I am writing regarding a householder planning application reference: **2024/62/93588/W**
Erection of two storey and single storey rear extension at 114 Slaithwaite Road, Meltham,
Holmfirth, HD9 5PW.

01.

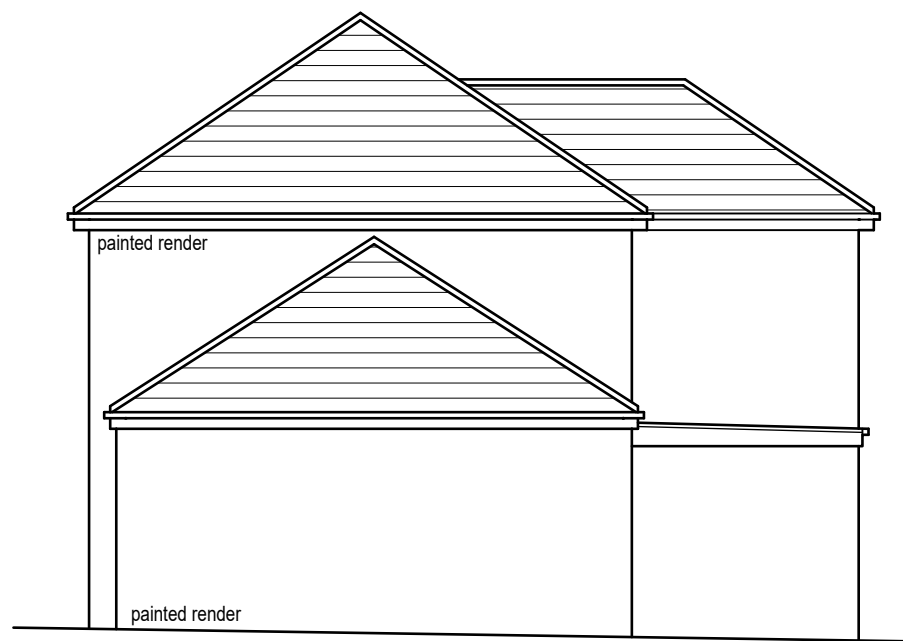
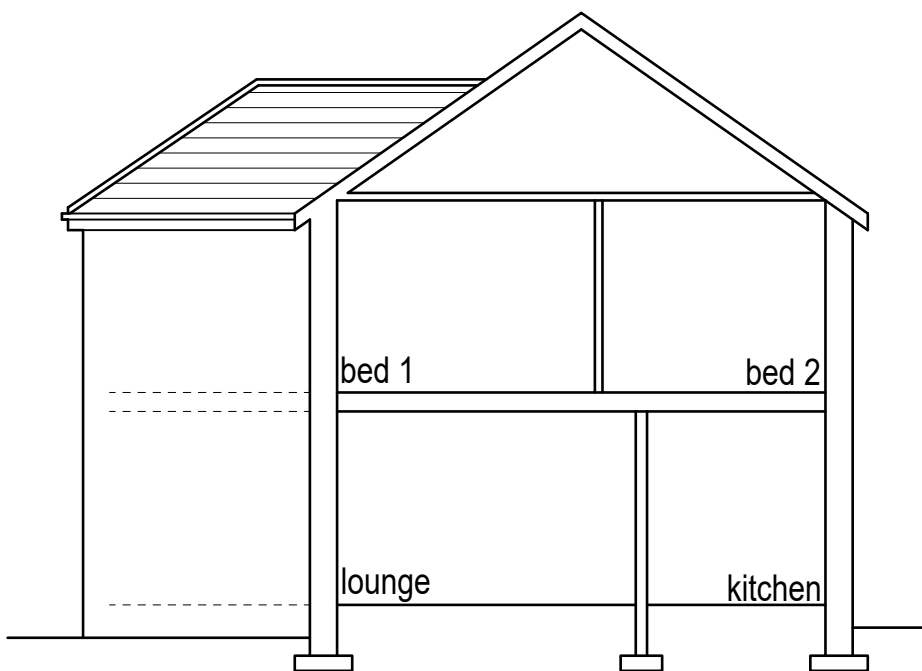
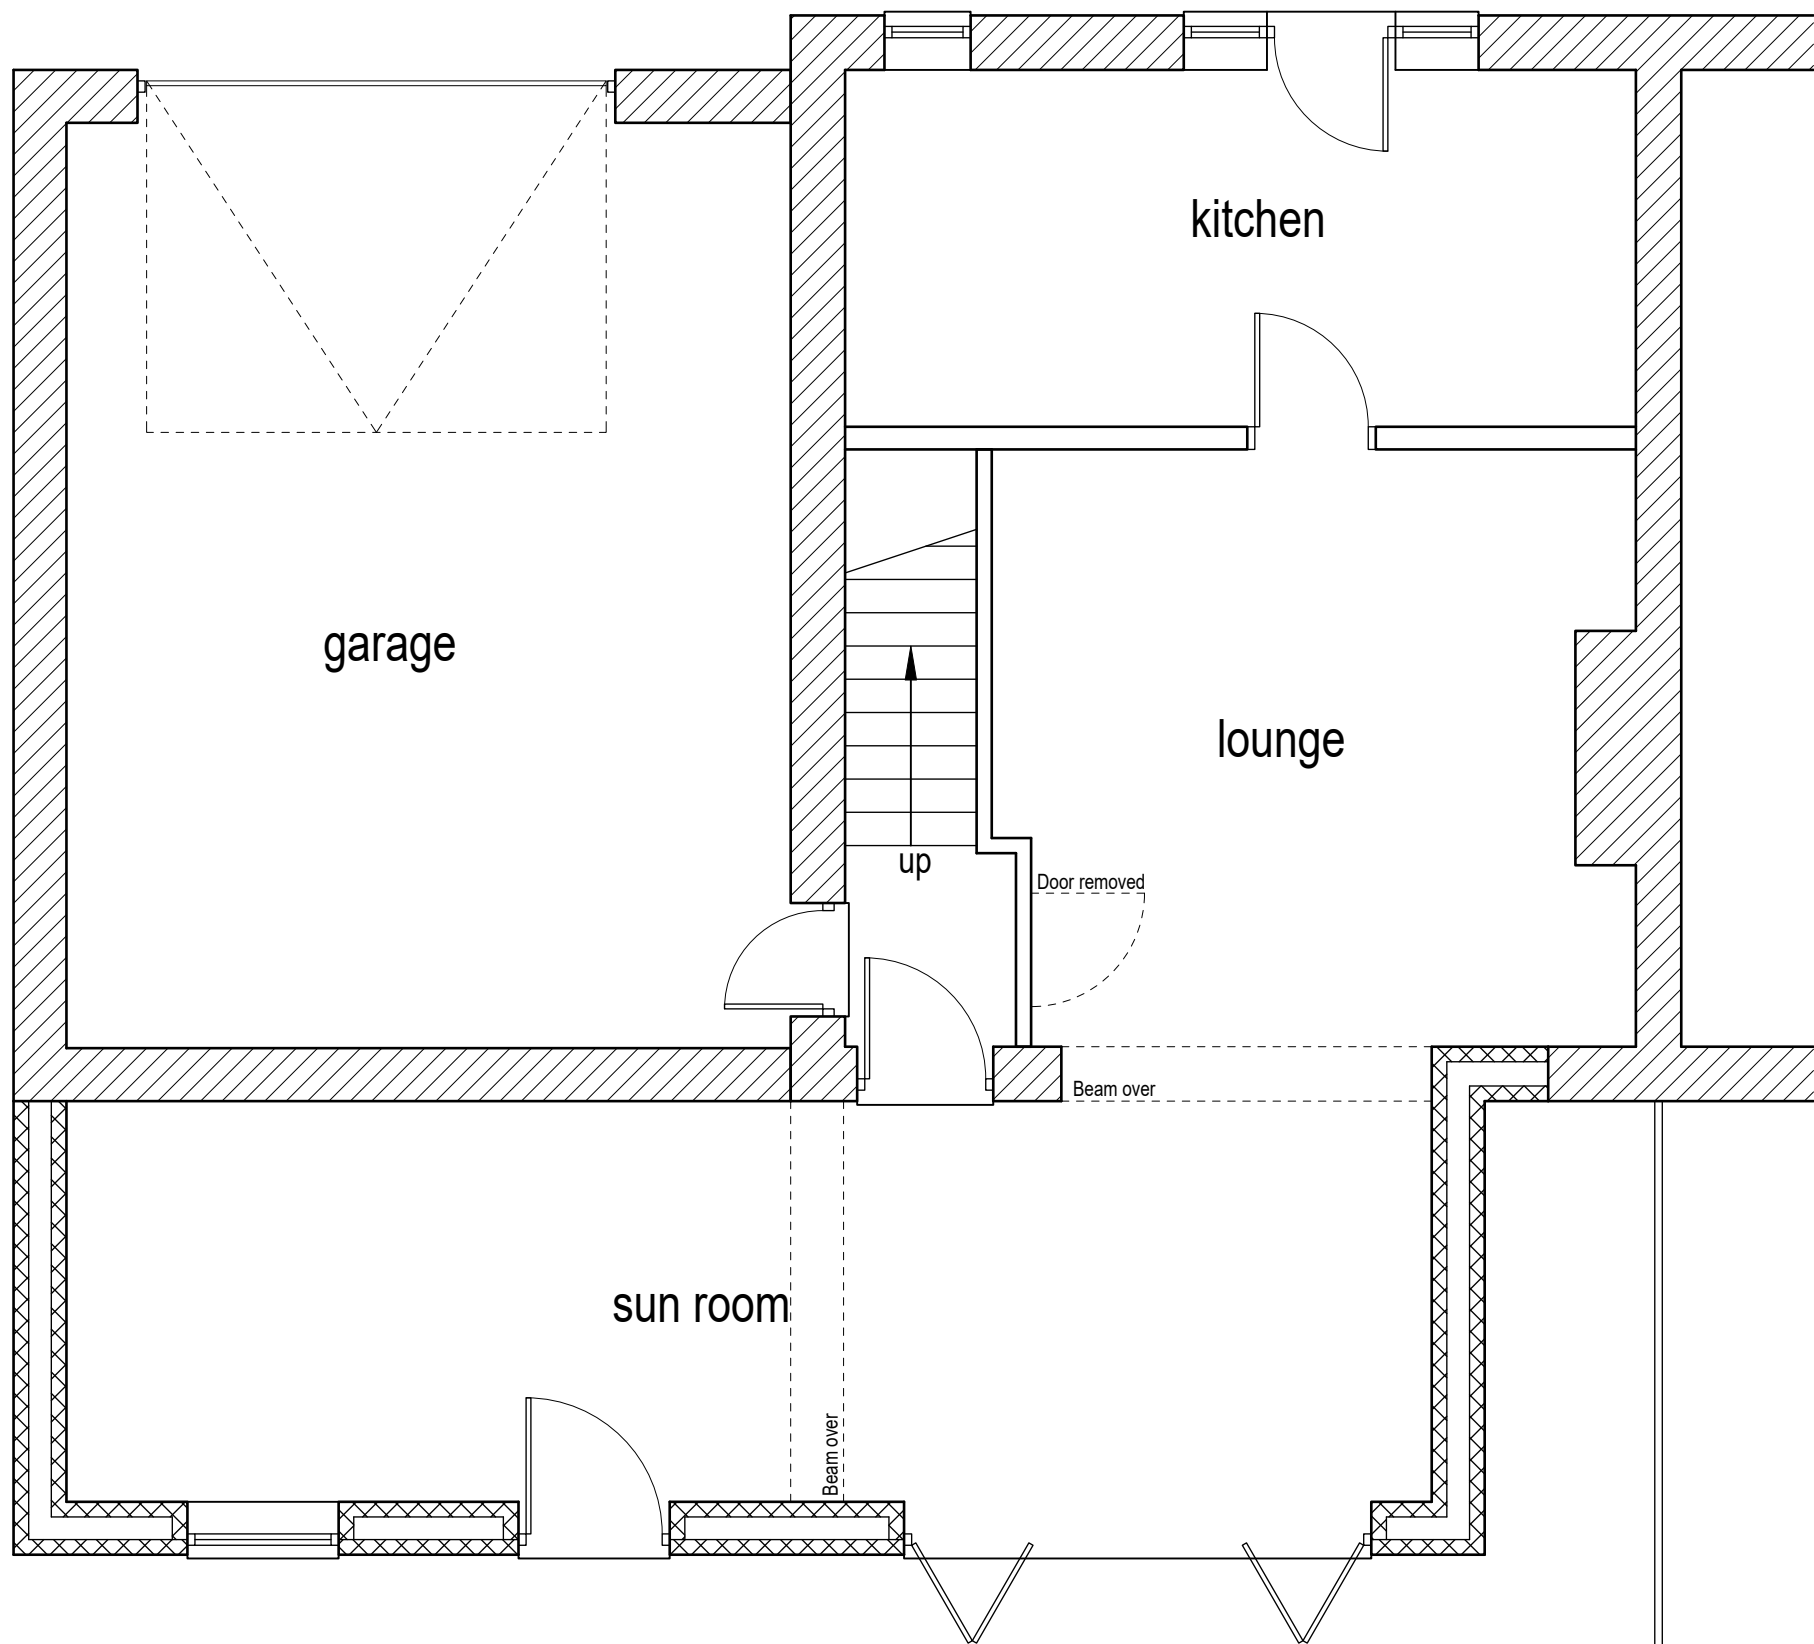
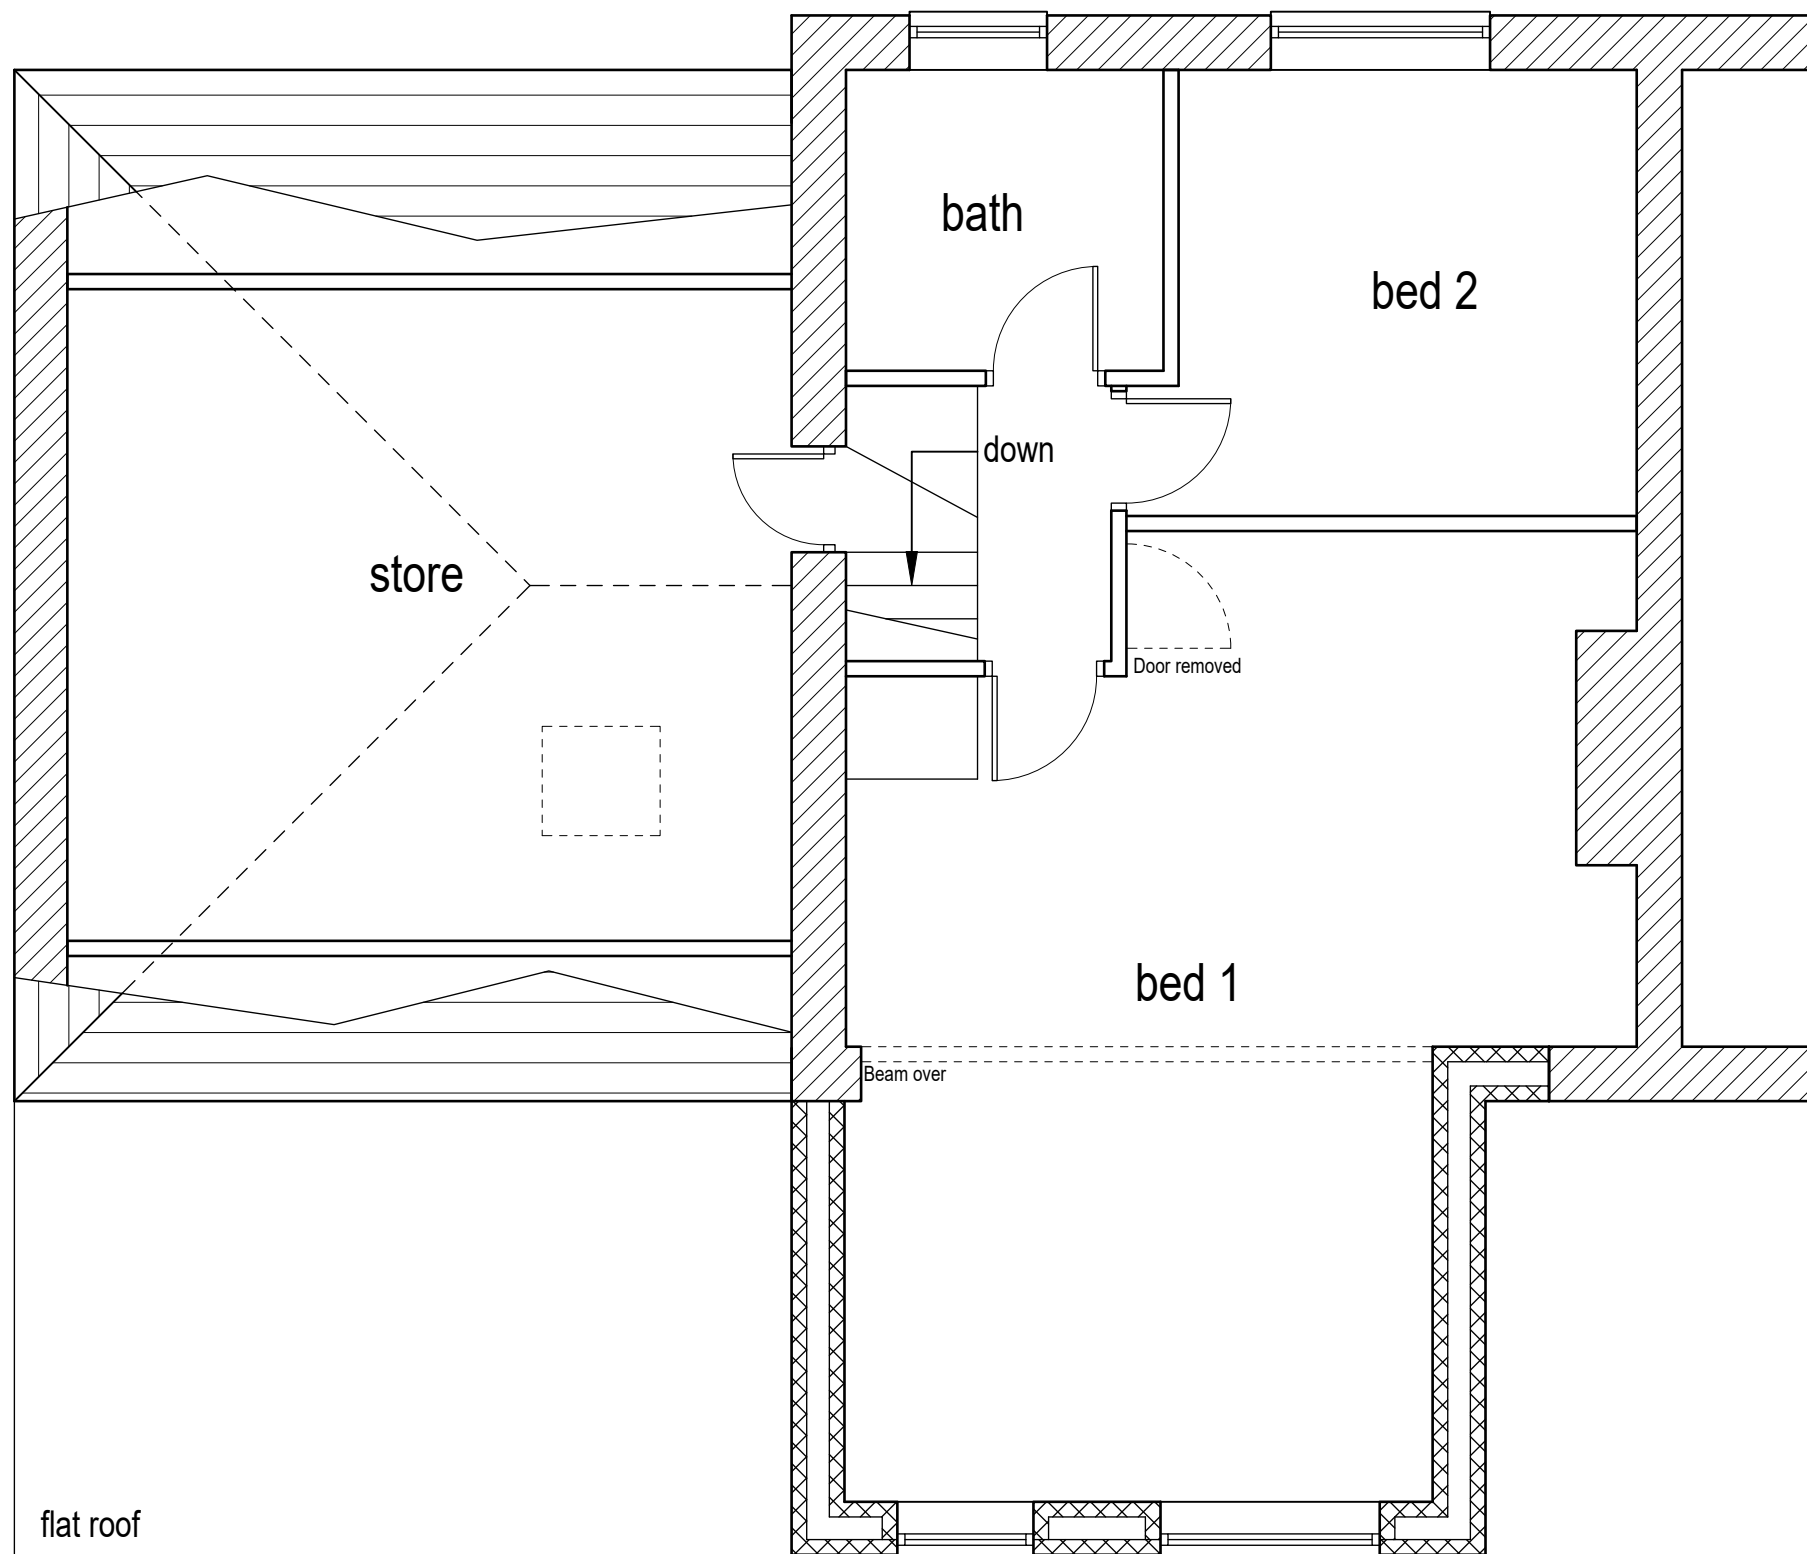
- The submitted drawings don't state how far the extension is set away from the boundary, nor the height of the extensions.
- The 2-storey rear extension is considered overbearing given the distance to my property and most notably adjacent ground and first floor habitable **bay** windows. We feel this will unreasonably overshadow habitable rooms and private garden areas and will materially affect the amount of natural light currently enjoyed by my property.
- Recently updated plans submitted show the 45 degree projection line to the centre of the bay window rather than the edge which again impacts on the natural light of my property.

- The single storey extension isn't in keeping with the host dwelling (flat roof)
- The extensions appear flush with the host dwelling and not set back therefore not appearing sub-ordinate to the host dwelling.
